Current Zoning: ML-2 (Manufacturing & Logistics 2)  
Proposed Zoning: IMU (CD) (Innovation Mixed-Use, Conditional)

Approximately 3.44 acres located on the west side of Westpark Drive, east of Interstate 77, and south of Tyvola Road.

The petition proposes to allow either 144 multifamily residential dwelling units or 144 hotel rooms within the existing buildings on the site.

Dwg No.
**REZ
1.0**

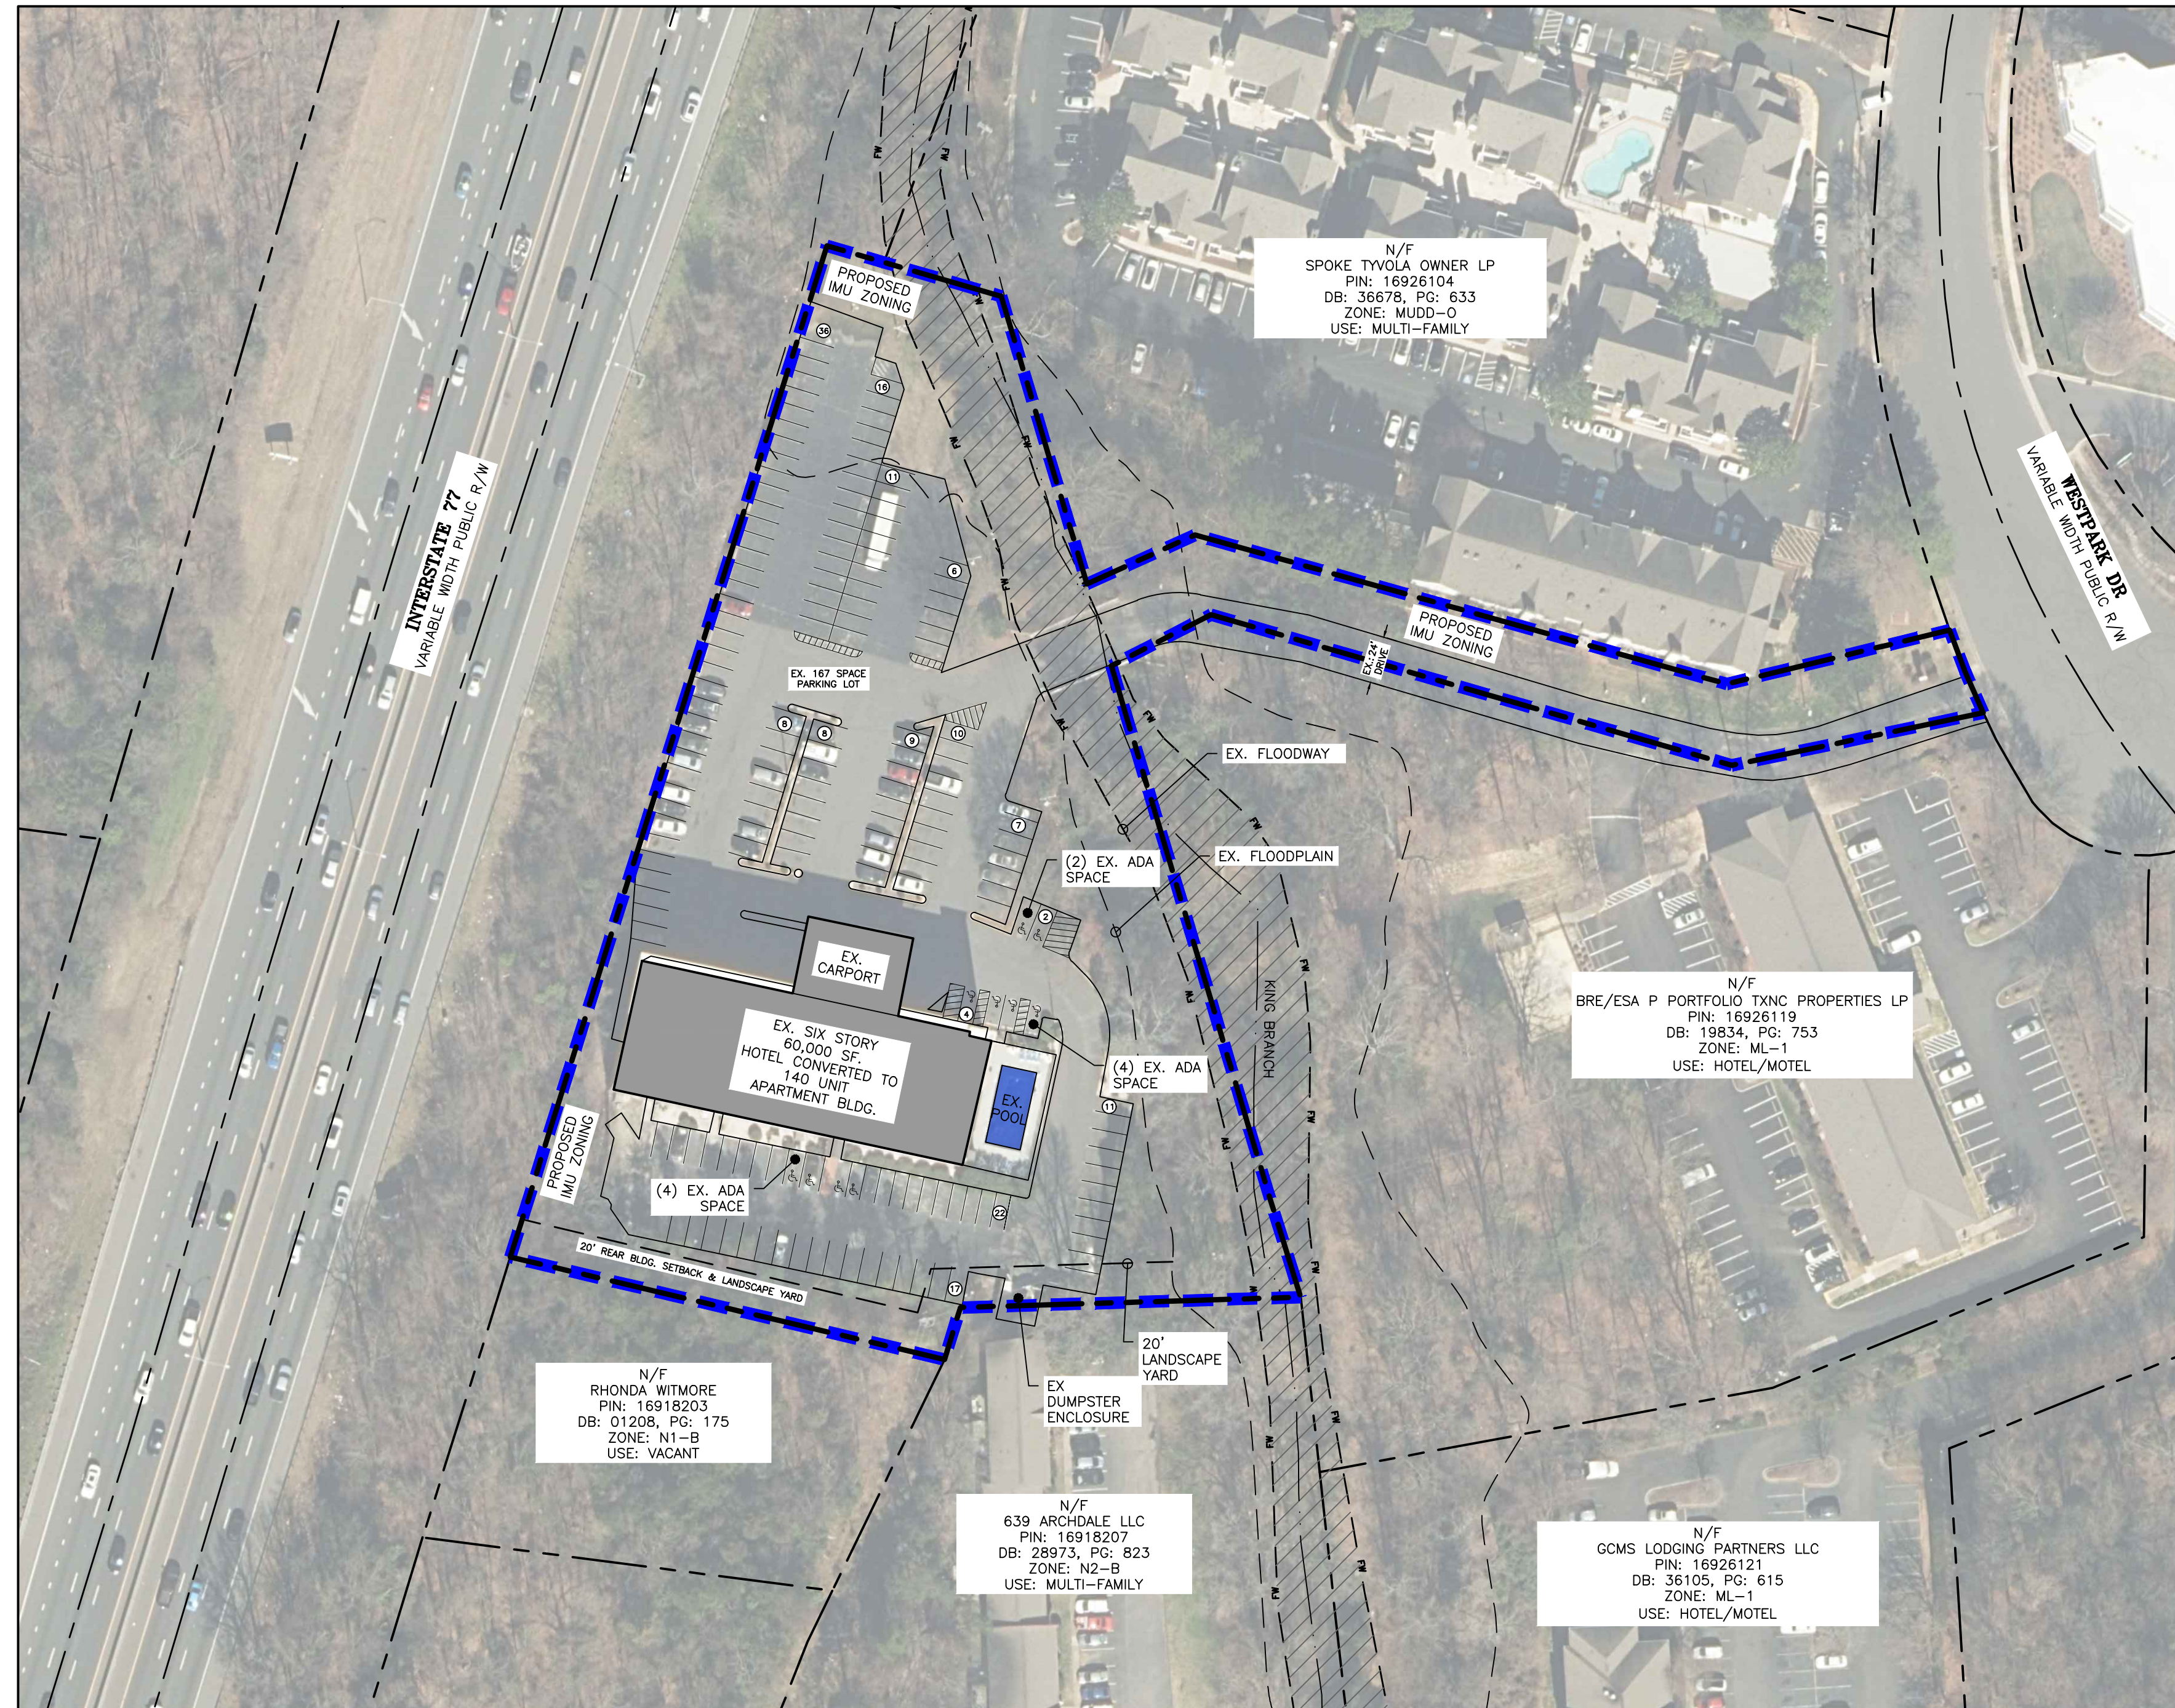
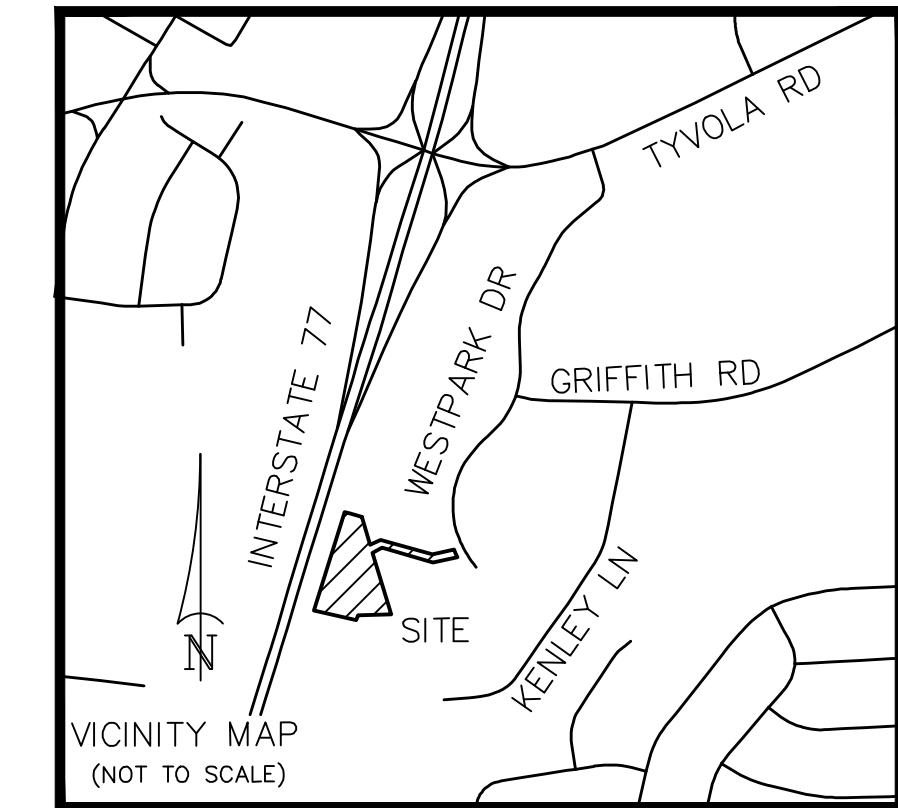
3. ~~MCPR requests the petitioner dedicate and convey a greenway and storm water easement to Mecklenburg County which would include whichever is larger of the 100' SWIM Buffer or the FEMA Floodplain of Kings Branch for a future connection to Kings Branch Greenway Trail. The easement can overlap the tree save areas and the existing paved driveway; however, the easement area should exclude the existing paved parking areas. The easement should be conveyed prior to the first CO. Revise site plan to label easement area as "stormwater and greenway easement" and add conditional note referencing the stormwater and greenway easement.~~ **ADDRESSED**
